Your Ref: OWPC24929
Our Ref: P/100/19/HH 10-10-2019
Please ask for:
Amber Willard

Single storey side extension and conversion of roofspace to habitable use to include a side dormer and conversion of roof from hip to gable end, and alterations to front bay windows

9 Kings Drive Pagham

dwg.title Proposed Elevations

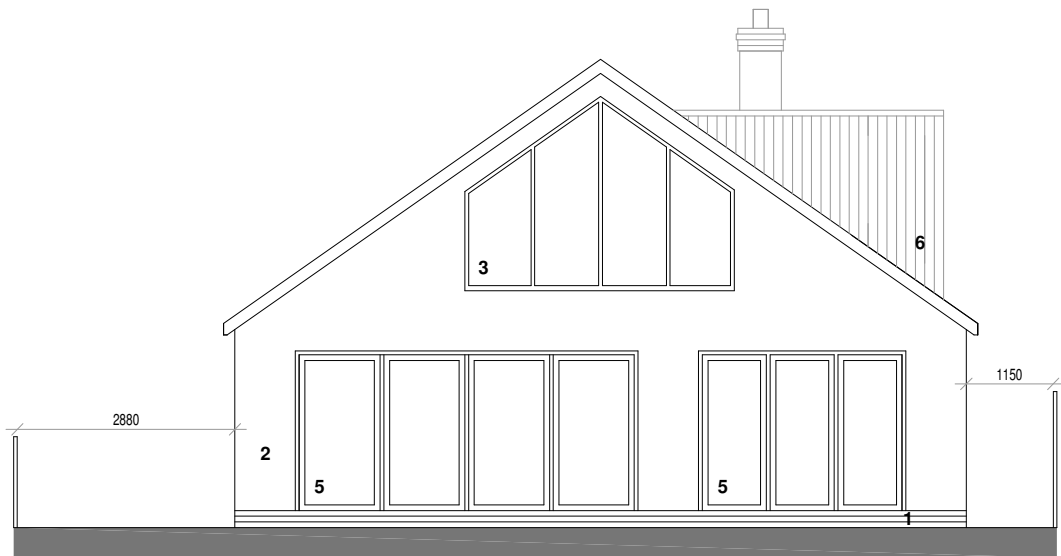
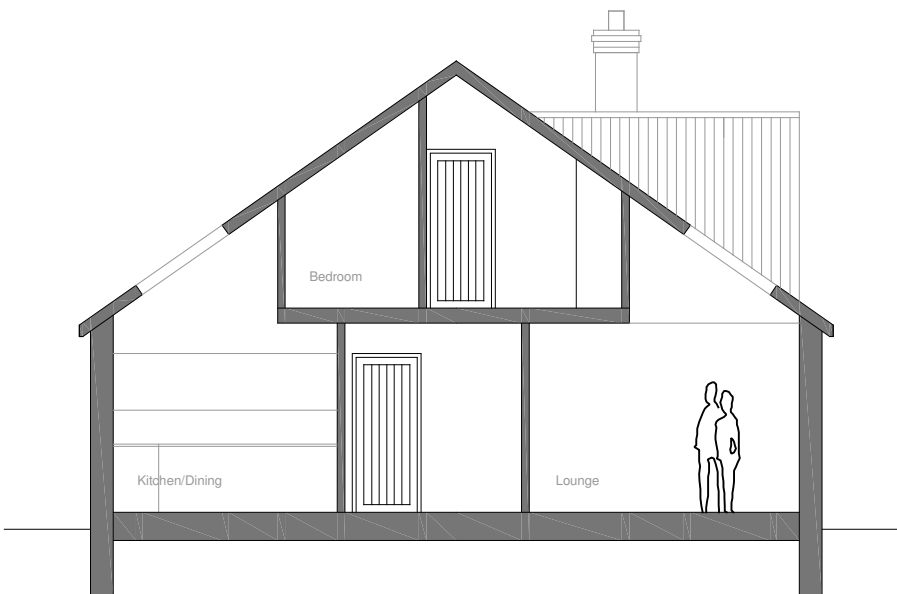
This extension will mean an encroachment of six metres towards my property, combined with a two storey gable end (West facing elevation) and a higher roof line than existing will mean the extended building will dominate the sky line and be disproportionately large and overbearing compared with all other surrounding properties. The inclusion of a floor to ceiling first floor window will allow the occupants to look directly down and into our property, therefore removing all our privacy. The applicant has already felled two fruit trees from the end of their garden which would have at least retained some privacy.
